CITY OF ALBUQUERQUE

**RE: 1510 John St
Grading and Drainage Plan
Engineer's Stamp Date: 12/29/25
Hydrology File: L14D071
Case # HYDR-2025-00460**

Based upon the information provided in your submittal received 01/06/2025, the Grading and Drainage Plan **is not approved** for Grading Permit and Building Permit. The following comments need to be addressed for approval of the above referenced project.

ENGINEER'S SEAL	LOT 11, BLOCK L, EASTERN ADDITION 1510 JOHN STREET	DRAWN BY MM
DAVID SOULE 14522 REGISTERED PROFESSIONAL ENGINEER		DATE 12-29-2025
	GRADING AND DRAINAGE PLAN	SHEET # C1
	<i>Rio Grande Engineering</i>	JOB #
DAVID SOULE P.E. #14522	P.O. BOX 93294 ALBUQUERQUE, NM 87199 (505) 321-9099

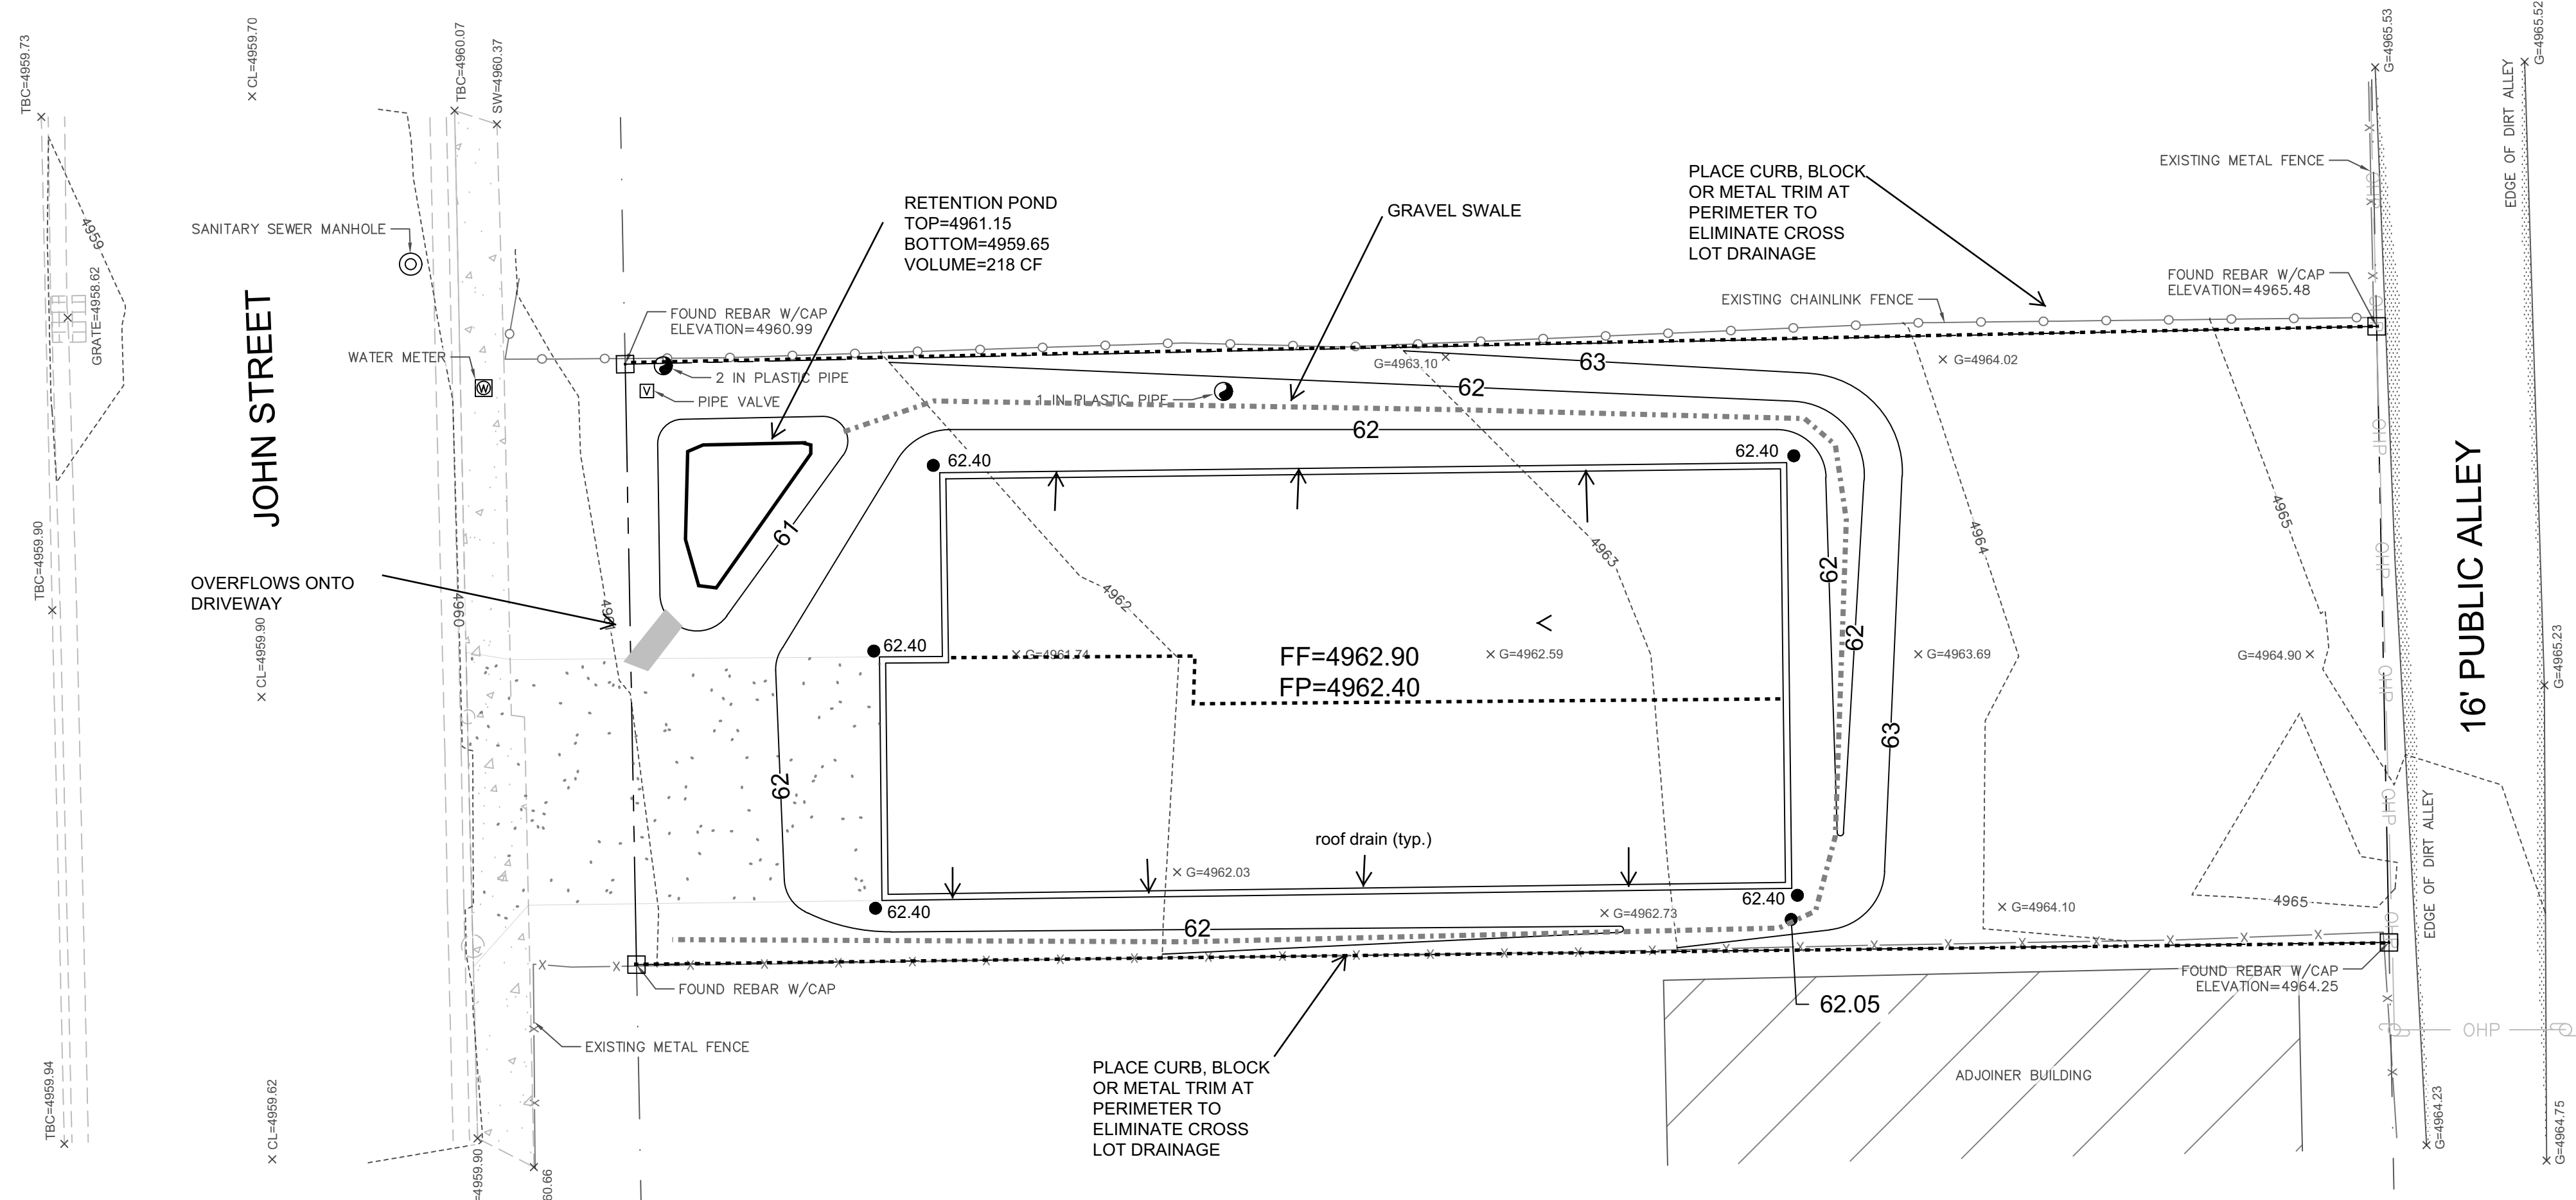
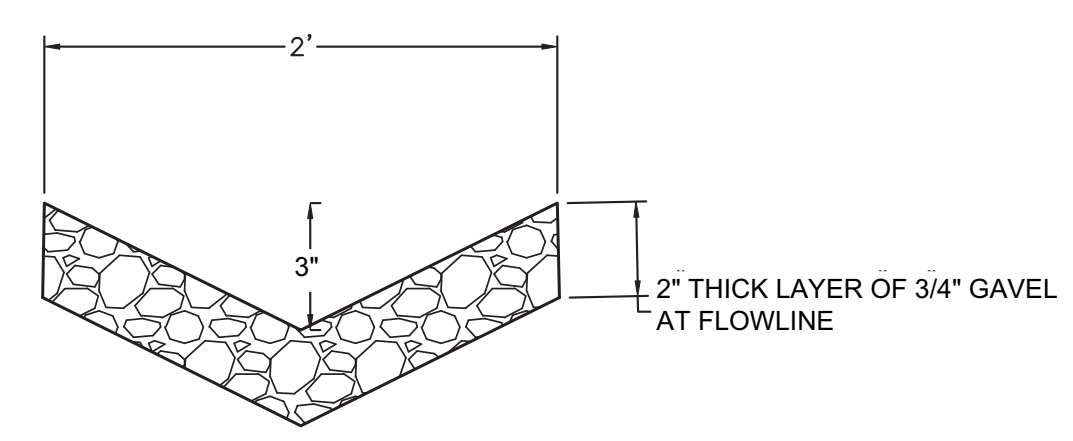
1. Zone 1 constants were used for calculations, please revise and resubmit using Zone 2 constants.
2. Since this site is in the Valley region, please follow Article 6-5 Valley Drainage Criteria of the DPM. The following conditions must be applied to the site:
 - a. A permanent perimeter wall or barrier on the North and South side of the development is required to contain the 100 year, 24-hour storm developed runoff.
3. Show swales clearly in the plans.
4. Show where the roof drains are located and where they will drain to.
5. Show the emergency pond overflow directed towards the driveway.
6. Please provide the FIRM Map floodplain note with effective date.
